December 23, 2022

**Re: Markana Flats at 7050 Constitution Ave NE
Erosion and Sediment Control Plan
Engineer's Stamp Date 12/12/2022 (L09E042)**

GPS COORDINATES: 35.093999, -106.567350

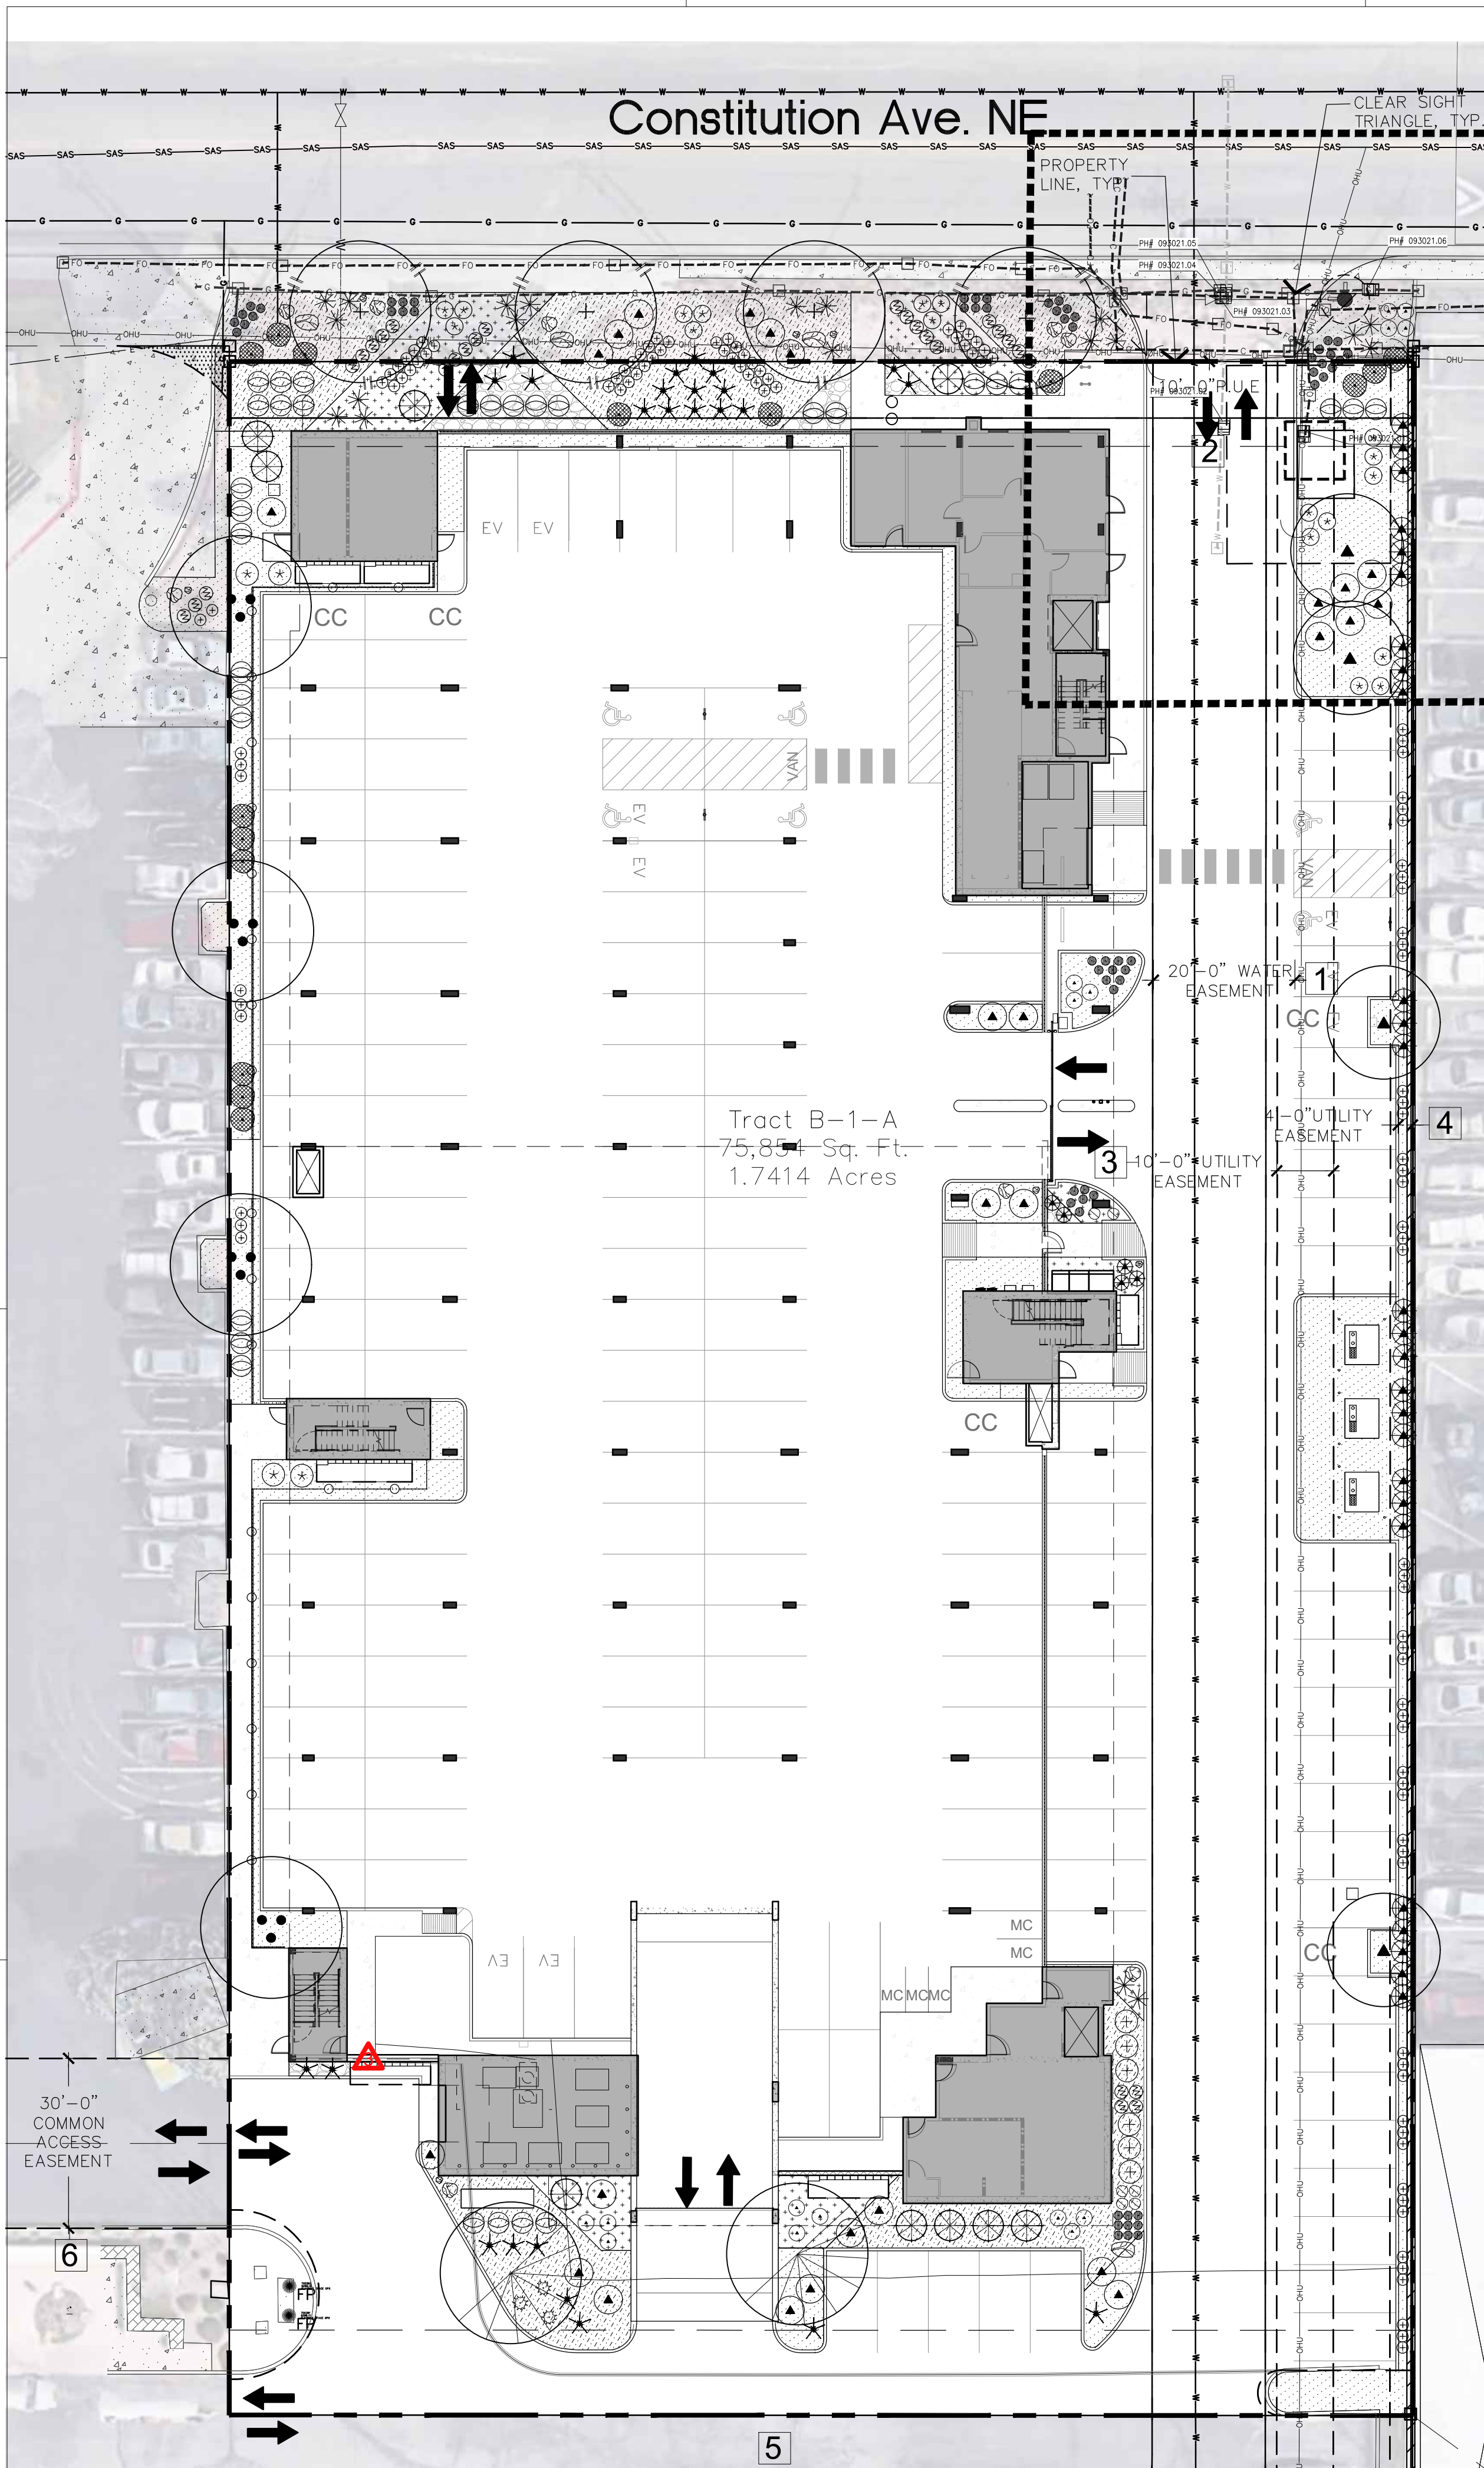
1. Corrections are needed on both NOIs and on the first sheet of the ESC Plan. The vicinity map and coordinates on Sheet 1 of 6 are located on Airport Blvd. NW. The coordinates on the NOI for KLG 10, LLC, NMR10059N, are in Santa Fe, and the coordinates on the contractor's NOI, NMR10054Q, are a quarter mile east of this site. The coordinates on sheet 2 of 6 are at the center of this site.
2. Silt Fence is required around the exposed perimeter (North, West, & South).
3. Staging is not allowed in the public right of way. Waste, washout, porta toilet, material storage and spill kit must be onsite.
4. Update the engineer's stamp date each time the plan is changed.
